From: Contact Centre (CRM) <contact@ribblevalley.gov.uk>
Sent: 13 June 2023 23:11
To: Planning
Subject: Planning Application Comments - 3/2023/0138 FS-Case-523743511

Planning Application Reference No.: 3/2023/0138

Address of Development: Twin Brook Farm
Upbrooks
Clitheroe
BB7 1PL

Title: Proposed Building 1

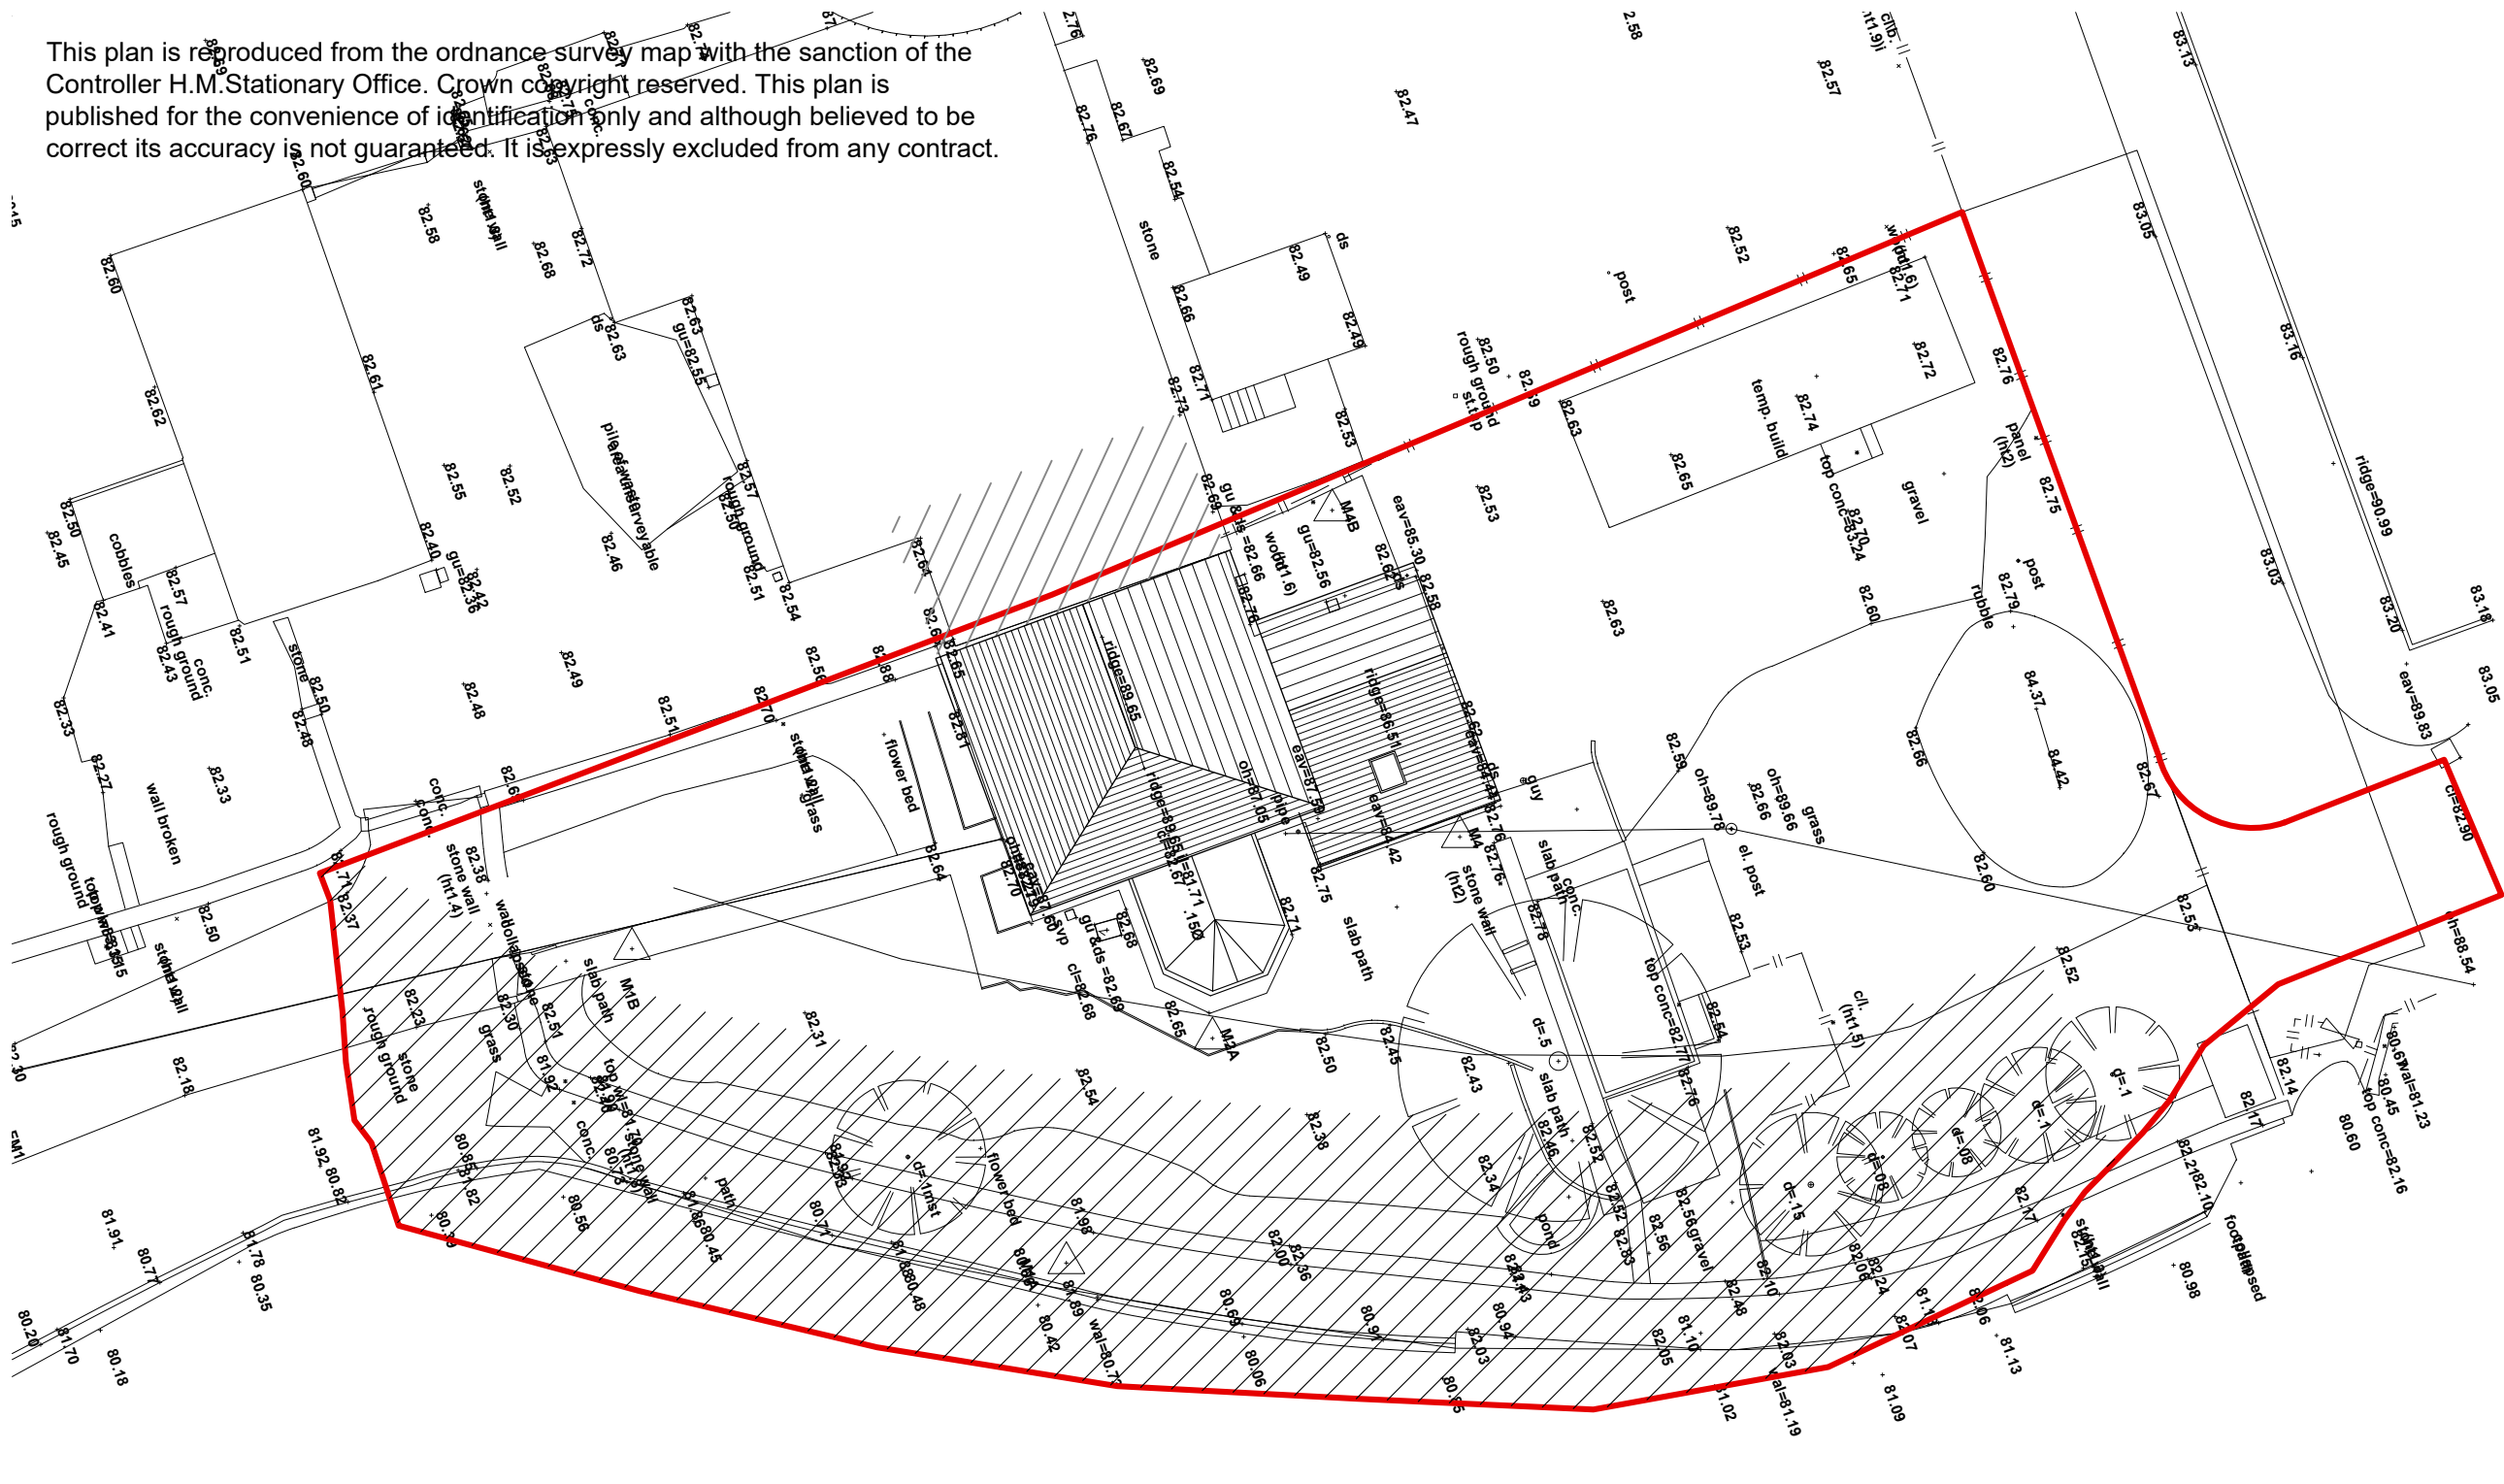
Our original contention that the site plans were inaccurate have proved to be correct. We have measured out the dimensions of building 2 from the original application and the building will not fit on the site and allow a drive way to the new development.

The application is only for a change from one detached house to a pair of semi detached houses, and ignores the fact that there is a material change to the size of the gardens and parking arrangements of Building 2 from the original application.

The car parking for the far semi detached house appears to be on land that was earmarked as a vegetation buffer as part of the approval for Twin Brook Industrial estate (See application 3/2016/1089 proposed site plan and also 3/2016/0401 tree scheme) In fact some of this land has already been changed from green buffer to a wood storage yard .

The scale of the new building is inappropriate to the location . It is over 2 meters higher than our building and due to its extra length will block out even more light.

It is also unclear from the plans what will happen to the public footpath that runs between the site and Mearley Brook, as with the original application , the site plans are unclear in this area.
